Engineers Comments Regarding Surface Water Drainage

Application Reference:	AL/118/25/DOC	Reviewer Reference:	ADC/EXT5/AF
Planning Officer:	Daun Johnson	Date of Review:	4/12/2025
Site Name:	Land to the North of The Haven and East of Northfields Lane Westergate PO22 3UH		
Application Description:	Approval of details reserved by condition imposed under AL/127/24/PL (APP/C3810/W/25/3358593) relating to condition 4-surface water drainage (see AL/118/25/DOC for discharge of conditions 3-Construction Environmental Management Plan, 7-Biodiversity Enhancement Plan, 10-Natural England licence and statement and 12-lighting)		
Assessment Number:	1

Response	Condition 4: Objection
-----------------	-------------------------------

Scale	Date	Drawn By	Checked By
1:200	Oct '2025	DJL	CT
Drawing No.	2025-C109-002	Rev.	-

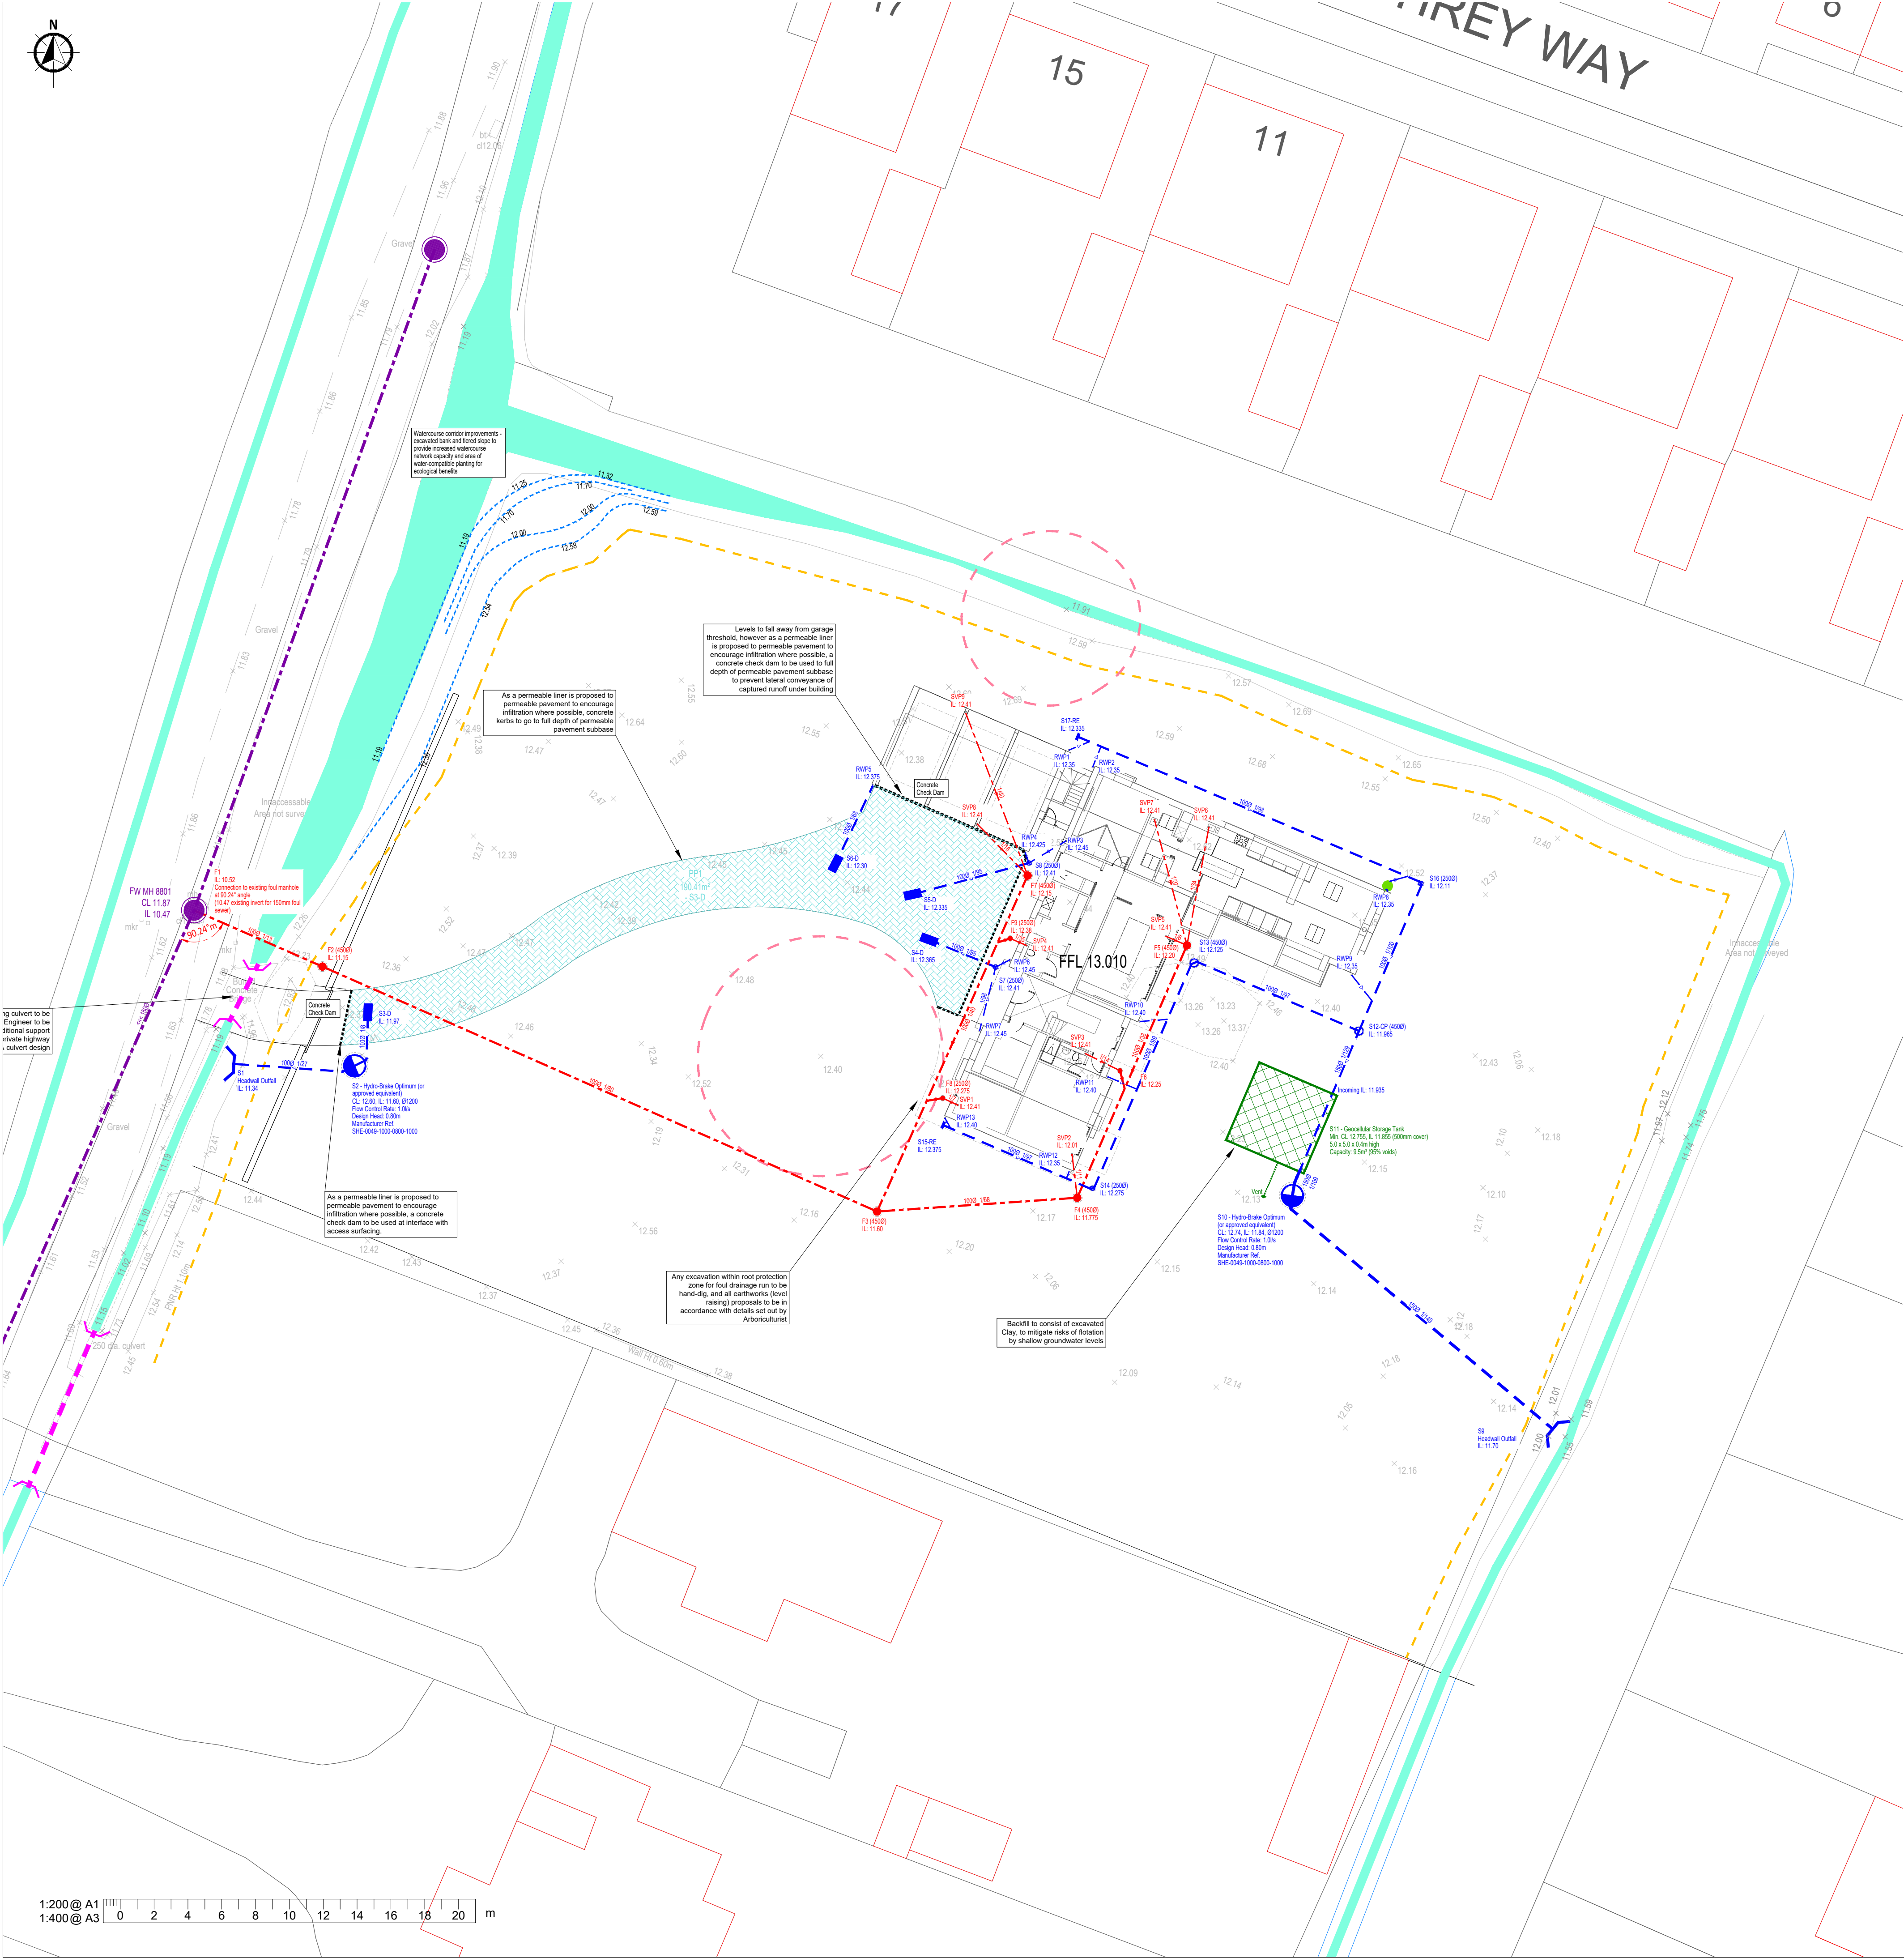
ADC Drainage Comments	Designer Response			
Date:	4/12/2025				
Condition Number: 4					
Comment Number					
1	The planning condition requires winter infiltration testing. None is submitted.				
2	The planning condition requires winter ground water monitoring. None is submitted. It must be evidenced that 1m unsaturated ground is provided between peak groundwater levels and the base of any infiltration feature.				
3	The design does not include provision of Interception Drainage in accordance with the National SuDS Standards.				
4	The planning condition requires an updated

impermeable areas plan. None is submitted. This should include a summary and total including urban creep allowance.				
5	The proposed design peak outflow rates are arbitrary and not restricted to greenfield runoff rates in accordance with the National SuDS Standards. Design flow restriction should be based upon greenfield runoff equivalent for the drained area and if necessary a relaxation applied where constraints preclude meeting the GFR rate. Modern flow controls can achieve rates much lower than 1l/s.				
6	The detailed drainage layout plans does not include finished surface levels. The base level of the permeable pavement storage should also be shown.				
7	The planning condition requires proof of consents for any discharge to watercourse. None are submitted. Ordinary Watercourse Consent is required for both outlets and the culverted section of exiting watercourse and

'watercourse corridor improvements' from WSCC.				
8	Construction details should be provided for all drainage elements.				
9	A surcharged outfall should be used in the drainage model for both outfalls and the design level justified.				
10	The permeable paving and flow control should be included in the drainage model.				
11	The watercourse connection to the rear appears to be outside the planning red line boundary. Confirmation of land ownership or Easement for construction and maintenance access is required together with proof of legal right to discharge to the watercourse if not the Riparian Proprietor.
